**RE: Response to Submissions – State Significant Development (16_7542)
RPA Hospital Multi-storey Staff Car Park**

ATTACHMENT A

REVIEW OF RESPONSE TO SUBMISSIONS

Figure 2: Detailed facade elevation showing the size of the perforations.

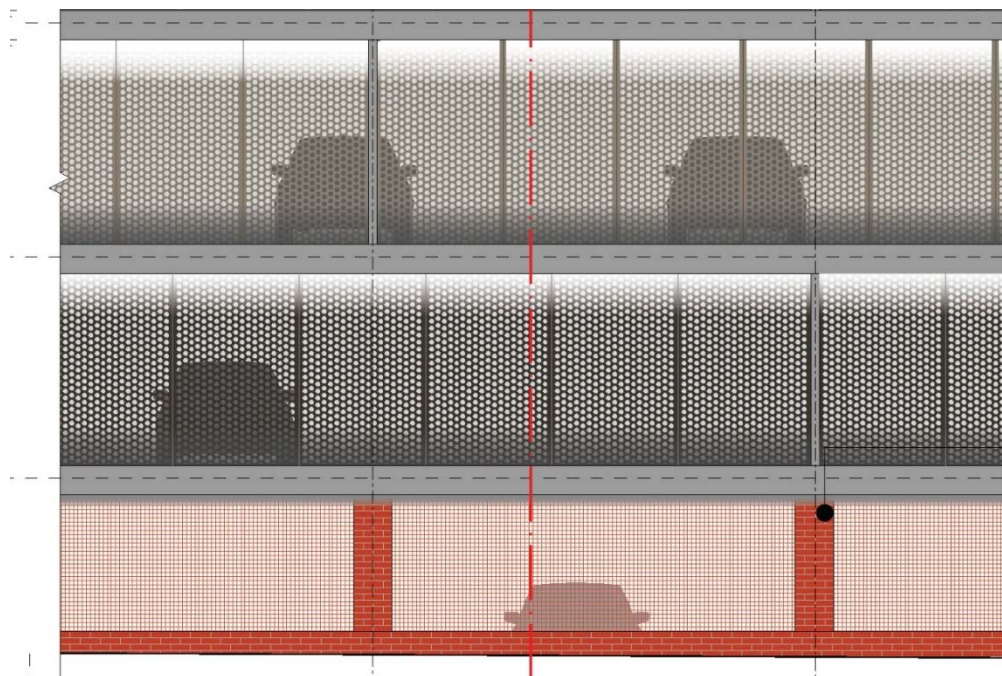
Light Spill			
The potential for negative impacts of light spill is not properly addressed in the application. The detail elevation on drawing DA-0204 shows that the perforations may be in the order of 75-100mm in size, despite being labelled as 'small'. This will allow the building to 'glow' at night time,	The potential impacts of light spill from the proposed development has been carefully considered during its detailed design: <ul style="list-style-type: none"> The perforations in the façade screens have a diameter of 	No	Amendments have not been made to the plans. Drawing DA-0204 depicts 'perforated metal A' as having perforation sizes in the order of 75-100mm.

Issue	Applicant's Response	Issue Addressed?	City's Contention
<p>as the scale of perforations does not provide any barrier to light spill.</p> <p>Currently proposed mitigation measures are limited to the top and bottom of the car park ramps on typical floors. This does not mitigate impacts to the remainder of the facades.</p> <p>It is recommended that additional mitigation measures be considered to ensure that light spill does not negatively impact the surrounding locality. Measures should also be implemented to prevent headlight beams shining directly into habitable rooms in the Queen Mary Building (QMB).</p>	<p>10mm (rather than 75-100mm) and as such serve to limit the extent of light spill in the surrounding area.</p> <ul style="list-style-type: none"> • No parking bays have been located immediately adjacent or perpendicular to the southern façade. • The major bulk of the building has been pulled back from the western boundary to reduce the impact on the residents of Church St. The entry and exit ramps have a solid 1200mm high barriers to reduce light spill from entering/existing cars. • Solid panels are to be fixed to the crash barriers within the car park to further block out direct light. 		<p>As the applicant is not amenable to amending the application to address the City's reasonable concerns regarding the impacts of light spill, a light spill report should be prepared and submitted prior to determination of the application. The report should confirm that the proposed design will not result in unacceptable amenity impacts to nearby sensitive receivers.</p>
